21 March 2024

Subject: SSD-29508870: Request for additional information

I refer to your letter dated 15 February 2024 in relation to a request for additional information associated with the *Birriwa Solar and Battery Project - Amendment Submissions Report*.

BARNEYS REEF ROAD - MC01

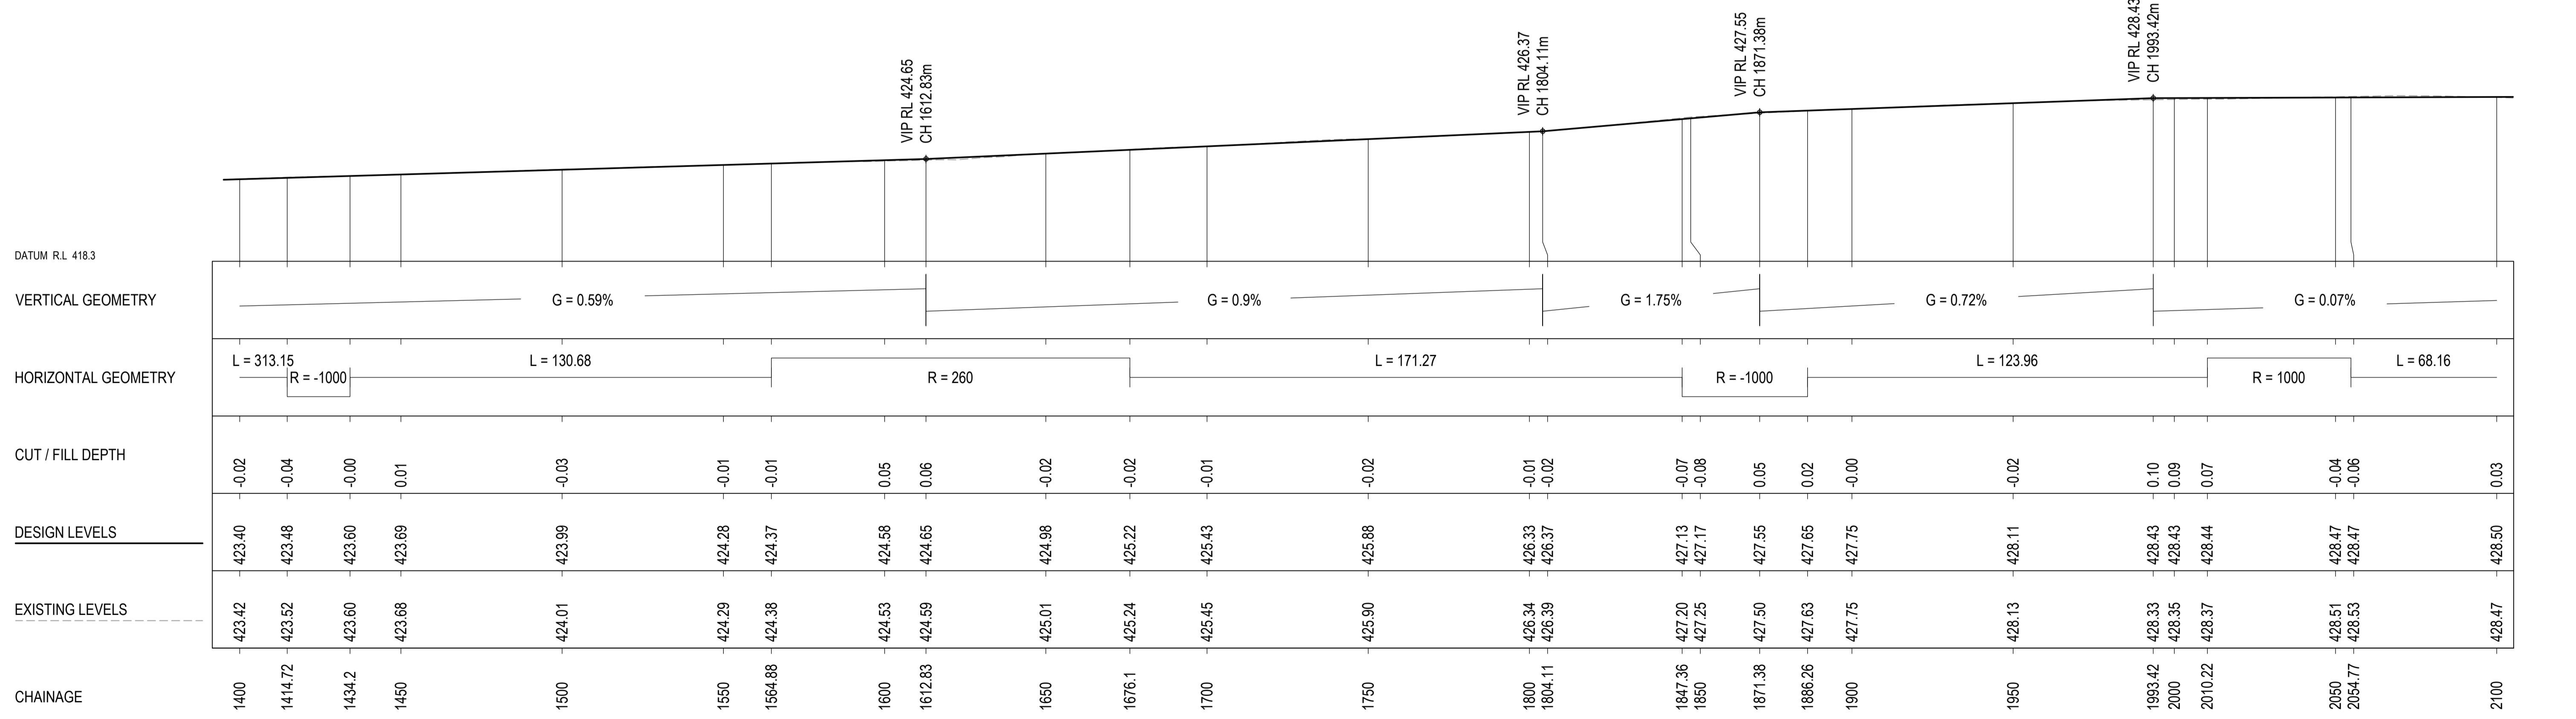
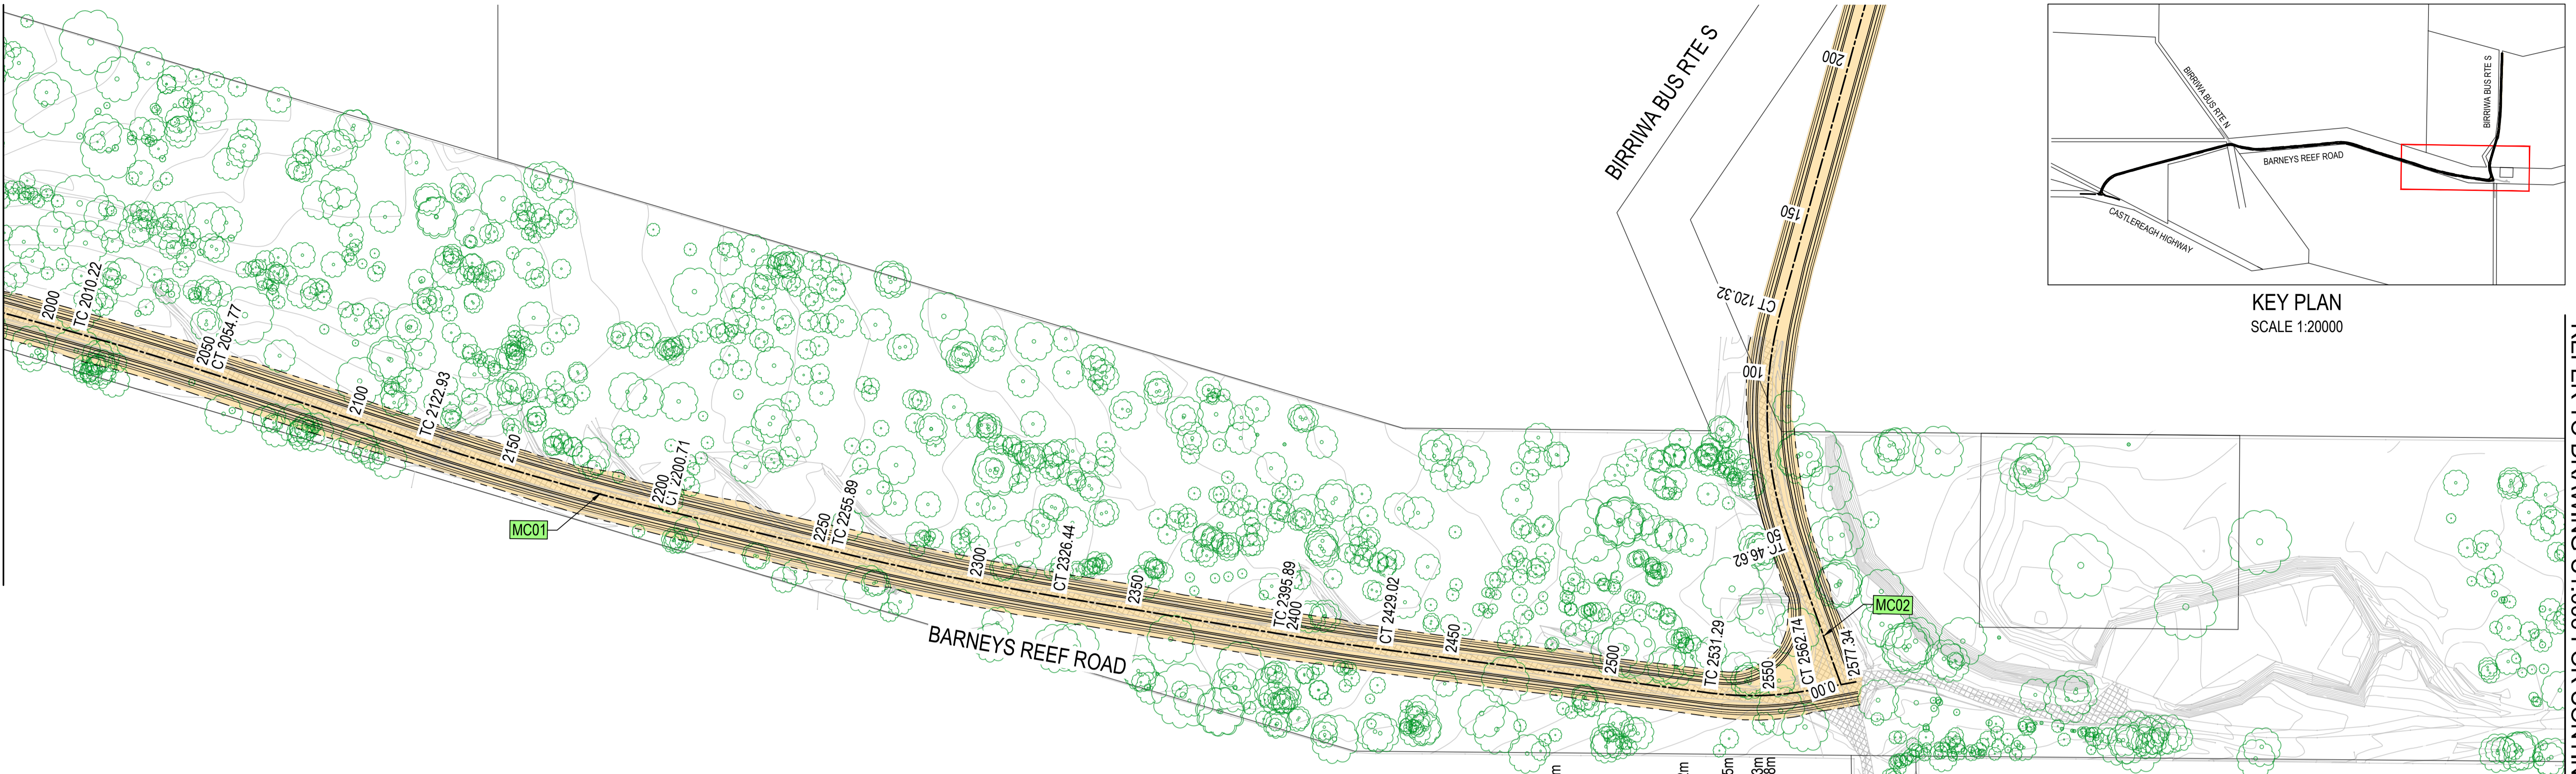
e) As discussed in the body of the letter; Regarding the intersection at Castlereagh and Barneys Reef Road (and will likely be required for Birriwa Bus Route Road/Castlereagh Highway), a 1m centre line and 2.5m shoulders are required to be provided in the revised strategic design for vehicle breakdown, or adequate width verge verified on design with 2.0m shoulder to allow a stationary vehicle to park clear. Provision of	TfNSW confirmed at a meeting on 7 March 2024 that 3.5 m lanes, 2 m sealed shoulders with 1 m verge, totalling 13 m carriageway width will be required with consideration of 6:1 batter within the road reserve. The strategic concept design (Appendix A) complies with the above requirements on the Castlereagh Highway. As per TfNSW requirements, SISD assessment was undertaken based on Figure 3.2 Austroads Part 4a: Unsignalised and Signalised Intersections at a driver's eye height of 1.25 m from the road level.

Feedback	Response
sight lines for SISD from driver eye height to target is also to be included in the strategic design.	
f) Strategic plans provided will need to verify the need for protection of culverts nearby to the intersection. The plans provided do not show all culverts surrounding the intersection.	The strategic concept design shows the locations of culverts in close proximity to the Castlereagh Highway/Barneys Reef Road intersection. Following the meeting with TfNSW on 7 March 2024, TfNSW confirmed that an assessment of culverts/bridges as part of the OSOM assessment is not required at this stage.

Fe	edback	Response
	refugee island as a part of the revised TIA.	
Po	ints of Clarification	
a)	Clarification on the extent of the use of Birriwa Bus Route to access the development. Strategic Design drawings are to be provided for any works proposed on the Birriwa Bus Route.	Birriwa Bus Route South will be to access the development between Barneys Reef Road and the site access. The total length of Barneys Reef Road to be used by the project is approximately 2.5 km. The total length of Birriwa Bus Route South is approximately 828 m. The strategic concept design drawings have been provided in Appendix A.

c) Effects of the development on adjoining property The property boundaries are shown in the strategic concept design (Appendix A). The plans show that works associated with the road upgrade on the eastern side of the Castlereagh Highway will encroach on Lot 7300 DP1149875 (Crown Land). Landowner's consent has been obtained for this Lot from Crown Lands.

Feedback	Response
boundaries surrounding the intersection must be included to highlight potential boundary issues.	
d) Property boundaries in relation to extents of development are to be demonstrated in detailed design.	The property boundaries are shown in the strategic concept design (Appendix A).
